**MAJOR PROJECT ASSESSMENT:  
Sydney Opera House - Stormwater Drain  
Diversion (MP09\_0122 MOD 1)**

Director-General's  
Environmental Assessment Report  
Section 75W of the  
*Environmental Planning and Assessment Act 1979*

October 2011

SOH - EASTERN SEA WALL Proposed Amendments to Stormwater Outlets

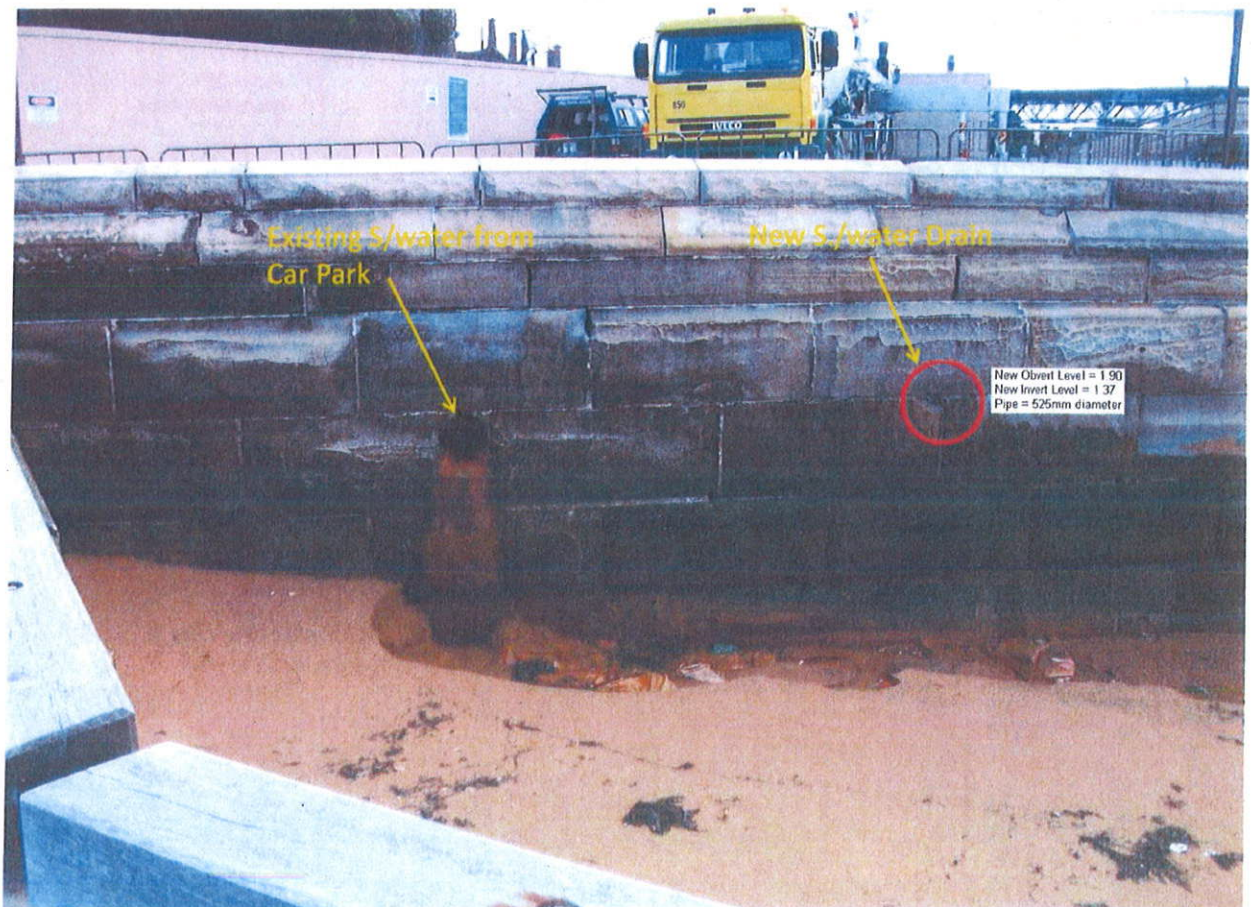
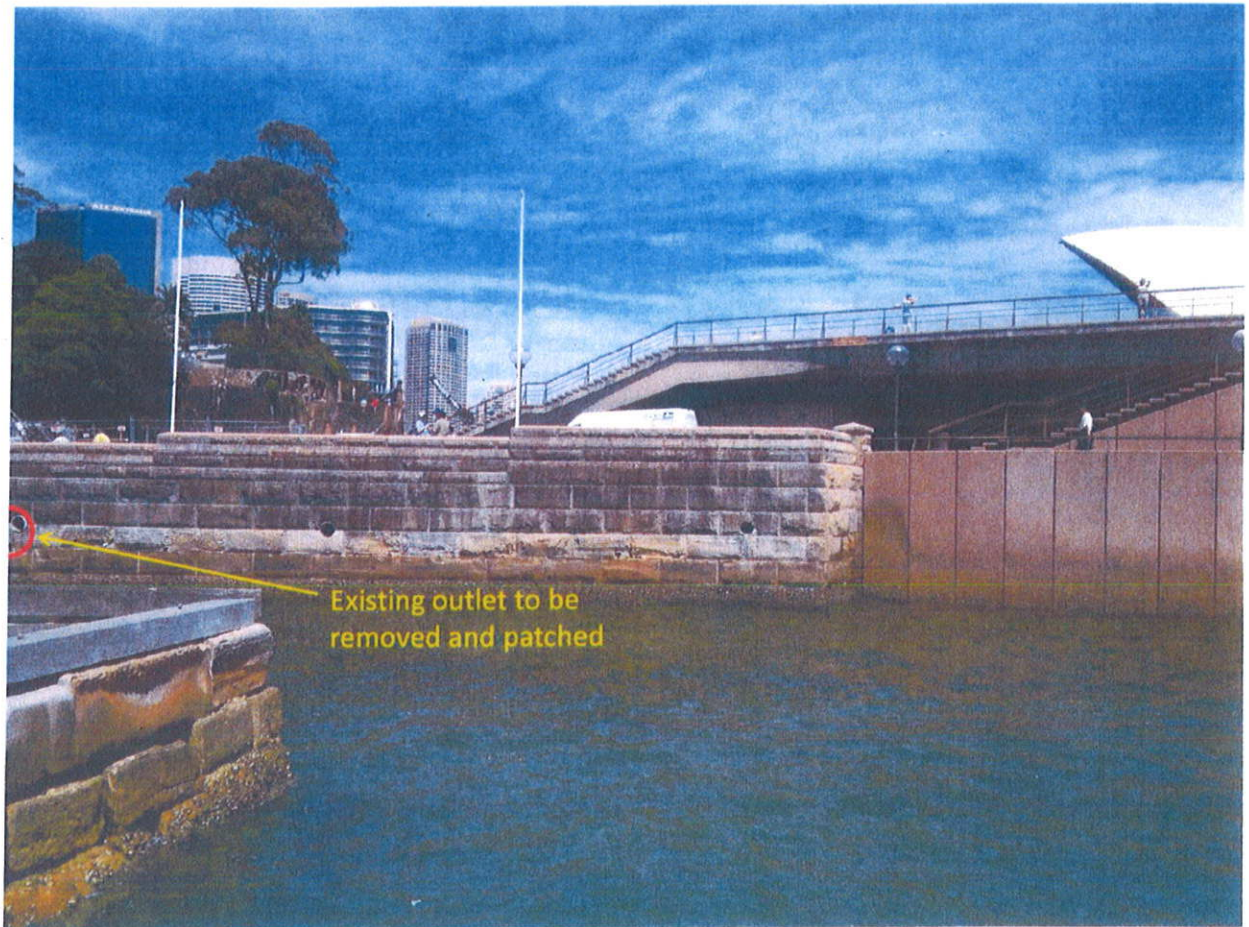
**Council of the City of Sydney (Tag B)** – considers the proposed outlet to be too large and visually intrusive at low tide, and has recommended that two smaller pipes and outlets be used in place of the proposed single pipe and outlet, and that these new outlets be well separated.

Council's suggestion of two smaller pipes instead of the one larger pipe was forwarded to the Proponent for their consideration. In response it has advised (**Tag I**) that the use of two smaller pipes was considered as an option but was dismissed for the following reasons:

- Using two pipes would require a larger upstream pit which, in turn, would increase the footprint of the excavation works;
- The opportunity to significantly separate two smaller outlets is extremely limited because of the presence of the plenum located towards the Opera House, and the existing outlet located towards the Botanical Gardens; and
- The pipe and outlet immediately to the right of the proposed outlet is covered by an Easement in favour of the Opera House car park operators and they have denied permission to connect into this service because of the risk of flooding the car park.

- that the stormwater outlet can not be reduced in size through bifurcation;
- with the plugging specification for the making good of the sandstone; and
- with the archaeological impact assessment report prepared by Godden Mackay Logan.

The Department and Council are both satisfied that the single pipe option is a superior option to the suggested twin pipe solution.
